**MODIFICATION REQUEST:
Residential and Child Care Centre
Development
14-18 Boondah Road Warriewood
MP10_0177 MOD 10**

Director-General's
Environmental Assessment Report
Section 75W of the
Environmental Planning and Assessment Act 1979

August 2012

CHILDCARE-POOL PLANS & ELEVS
SCALE 1:200

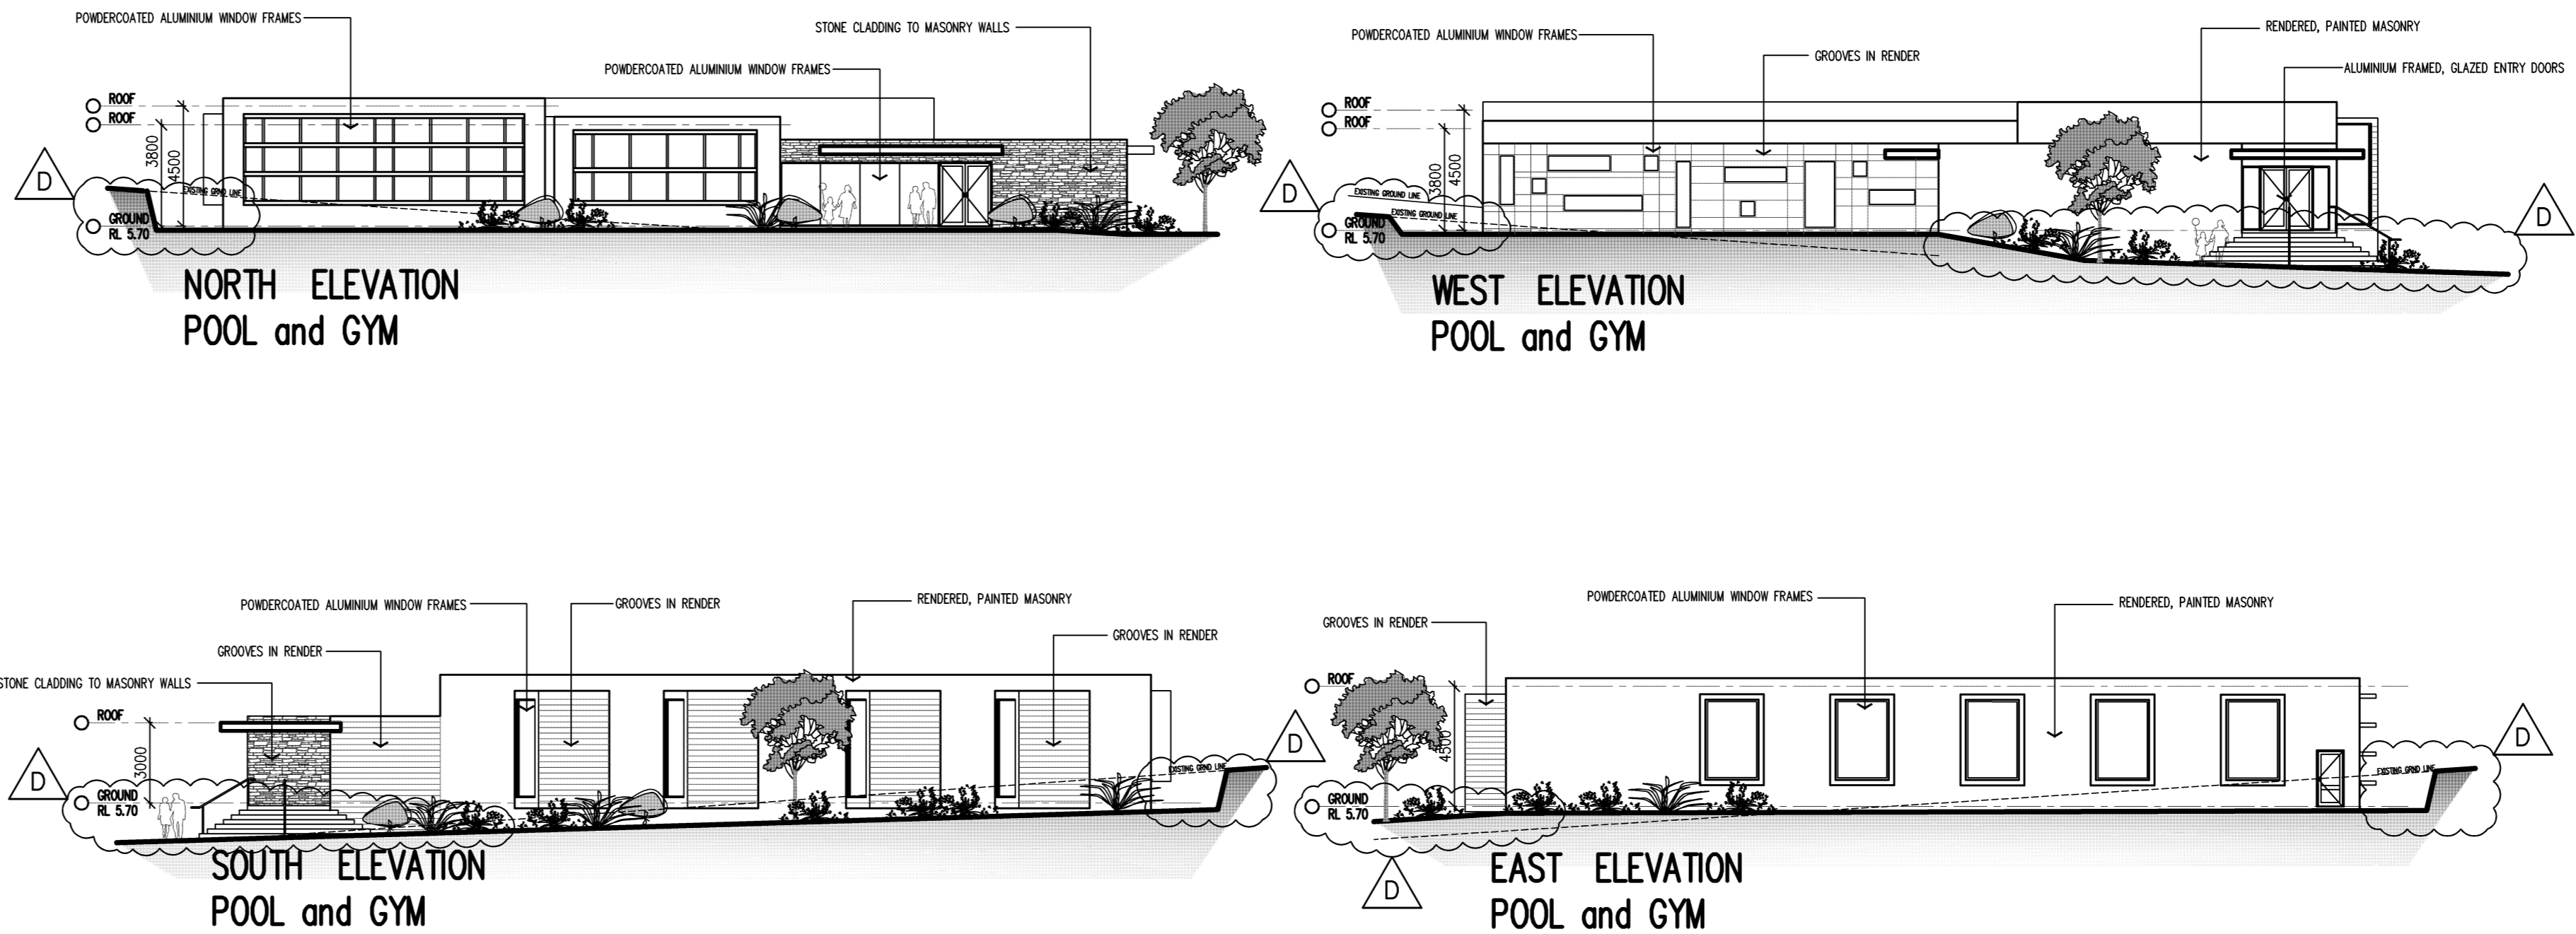
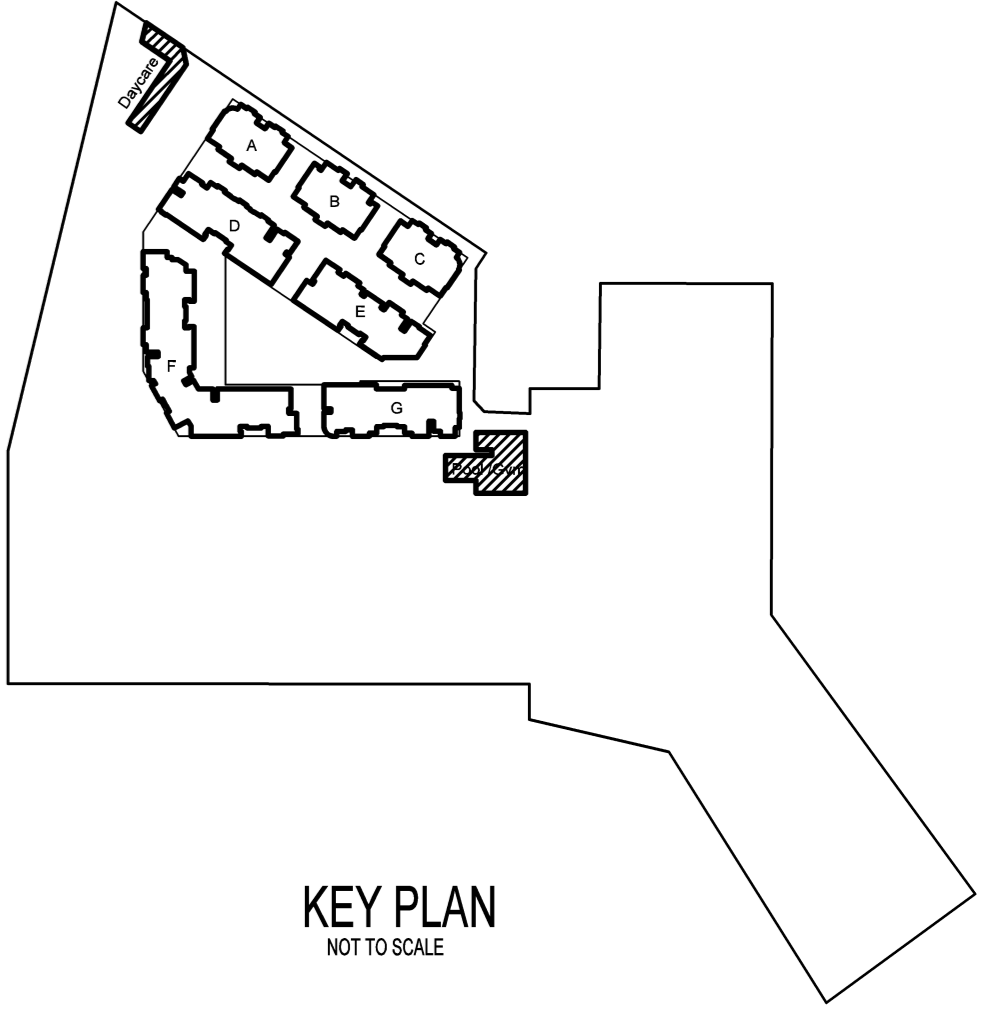
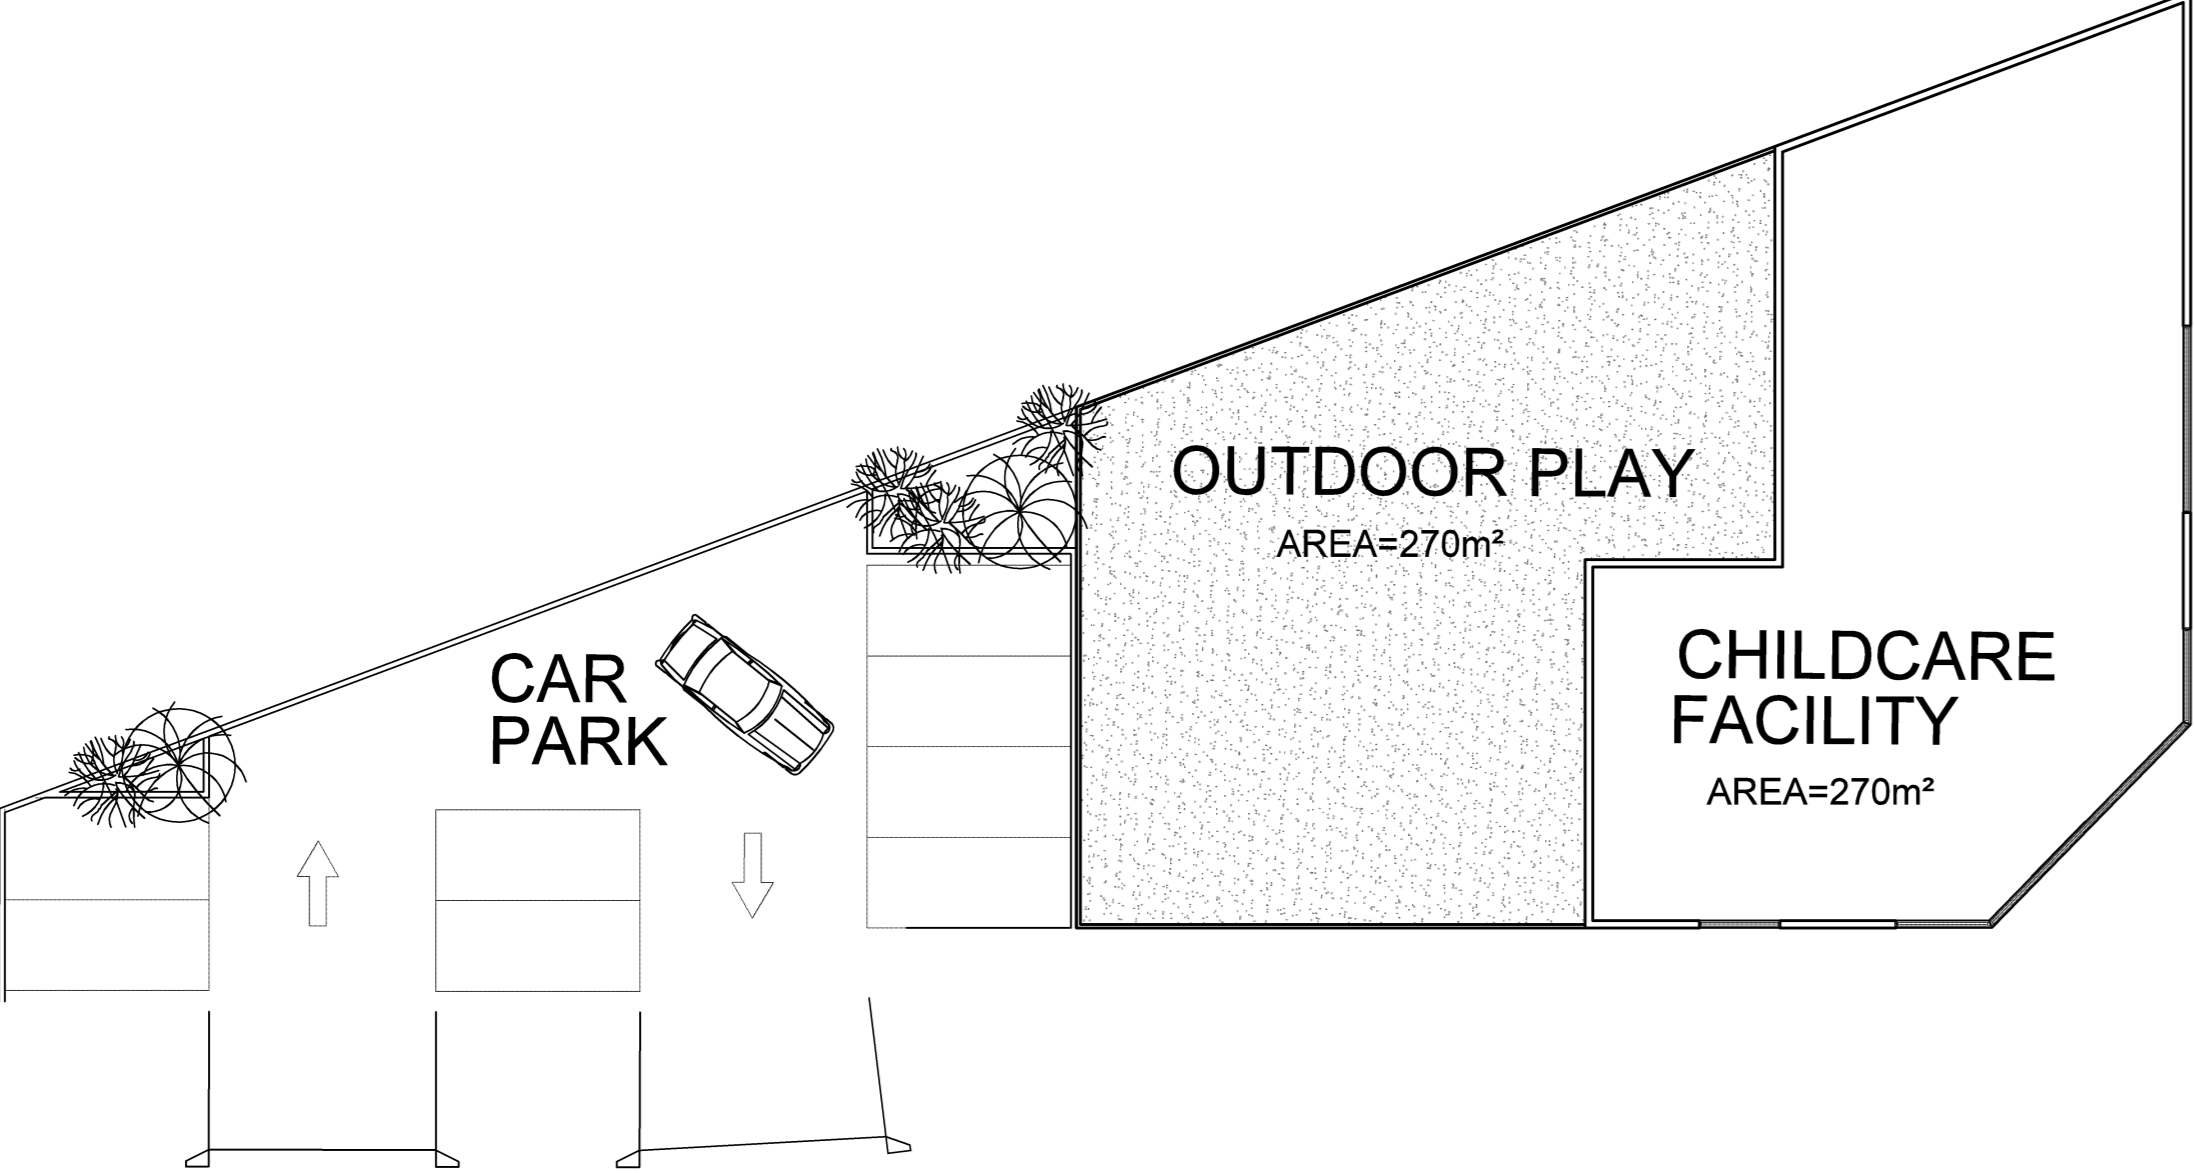
The pool building is proposed to be raised by 700mm so that the ground floor FFL is changed from RL 5.00 to RL 5.70. The level of the building is raised so that the floor level will be more consistent with the natural ground level. In other words, the proposal seeks to reduce the amount of building required to be built below ground level.

The design of the building including the overall building height and floor to ceiling height otherwise remains unchanged. As a result, there will be a marginal increase in the height of the building of 700mm. The Department raises no issue with the additional 700mm height of the single storey building as it would not pose a significant impact on the amenity of residents particularly given the building is only single storey in height and is surrounded by buildings of four to five storeys in height.

In this regard, the Department raises no issue with the proposed raising of the pool building.
